Our Ref: BR/245/19/HH
Your Ref:

Town & Country Planning Act 1990 (as amended)
Town & Country Planning (Development Management Procedure) (England) Order 2015
Application for Planning Permission for Works or Extension to a Dwelling

Development Single storey side annexe extension
Location 28 Hatherleigh Gardens Bognor Regis

sheet 1 of 3

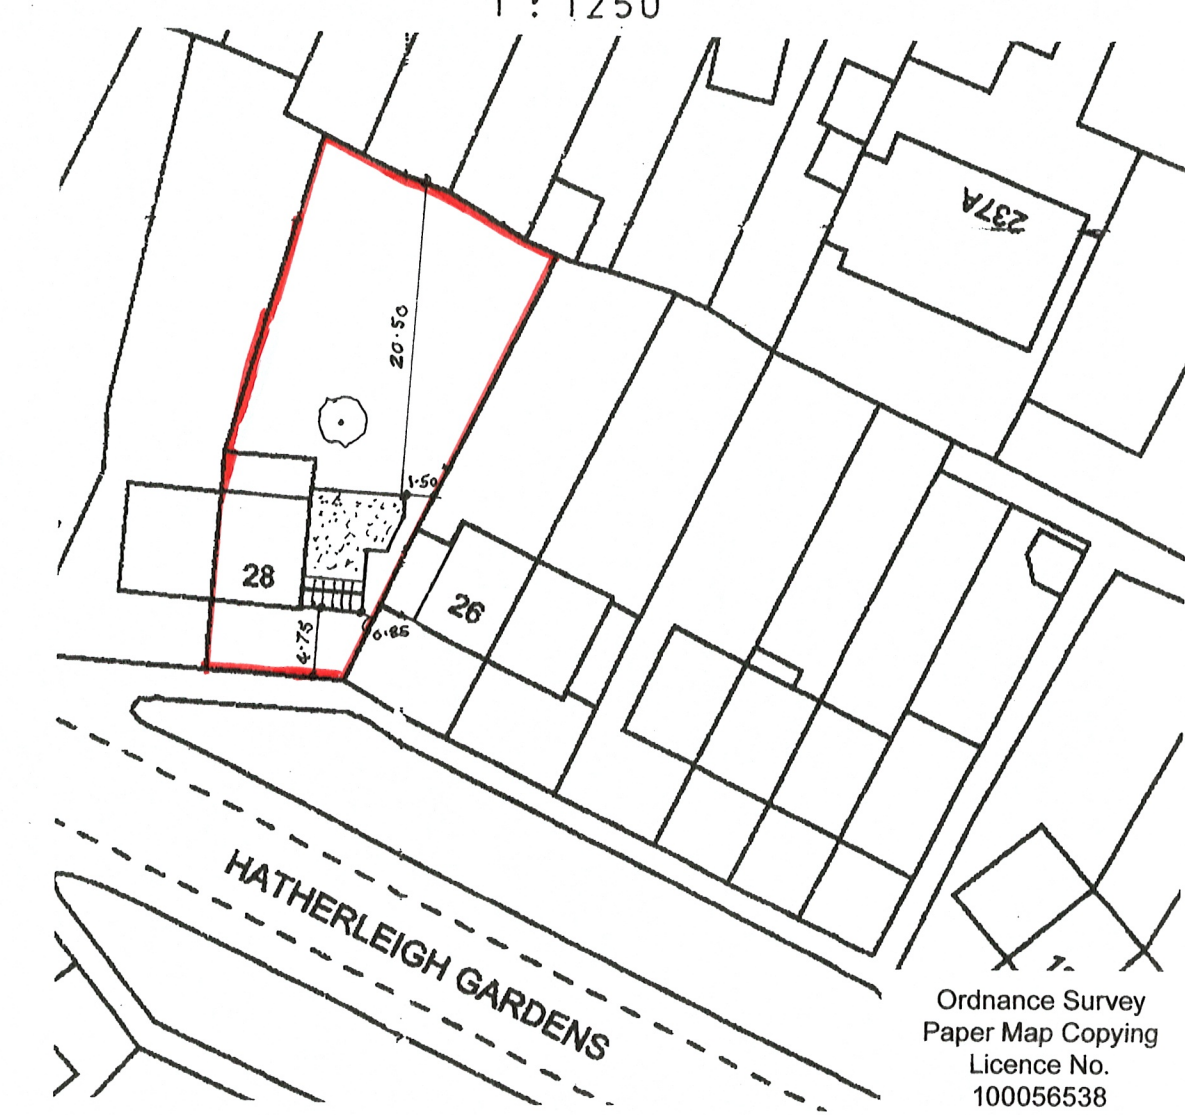
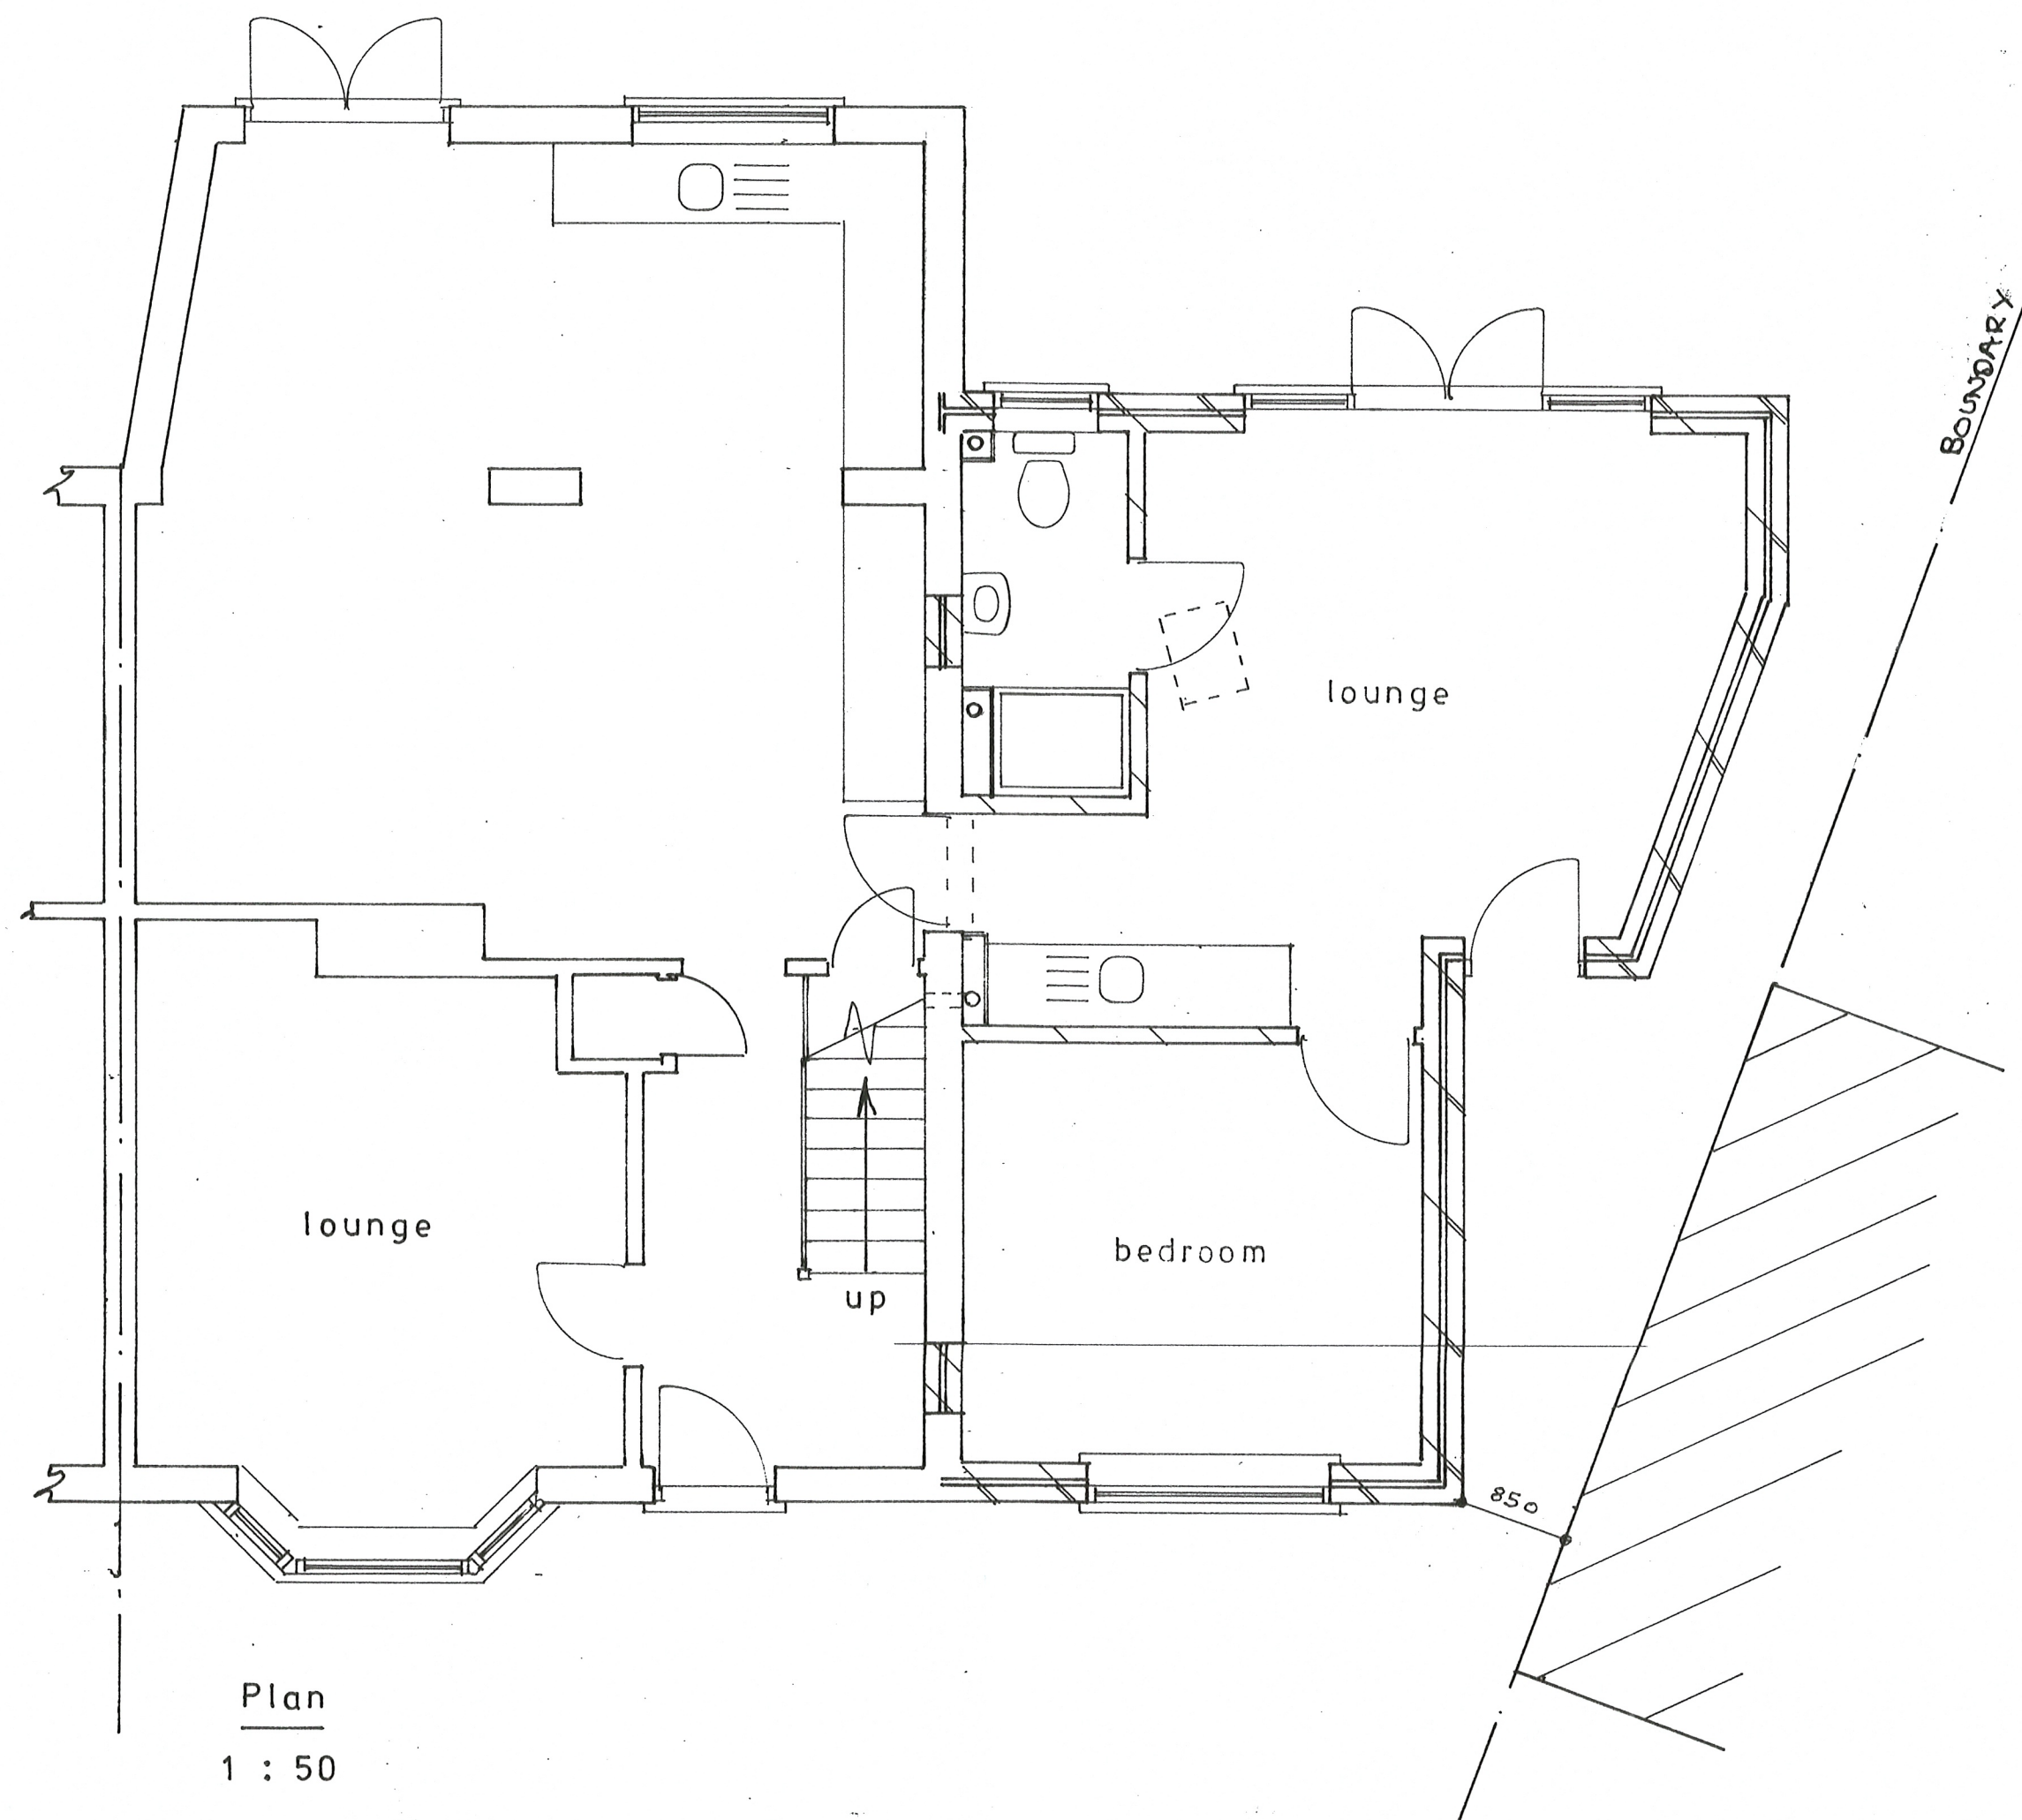
Please amend the Block Plan to show dimension to rear boundary.
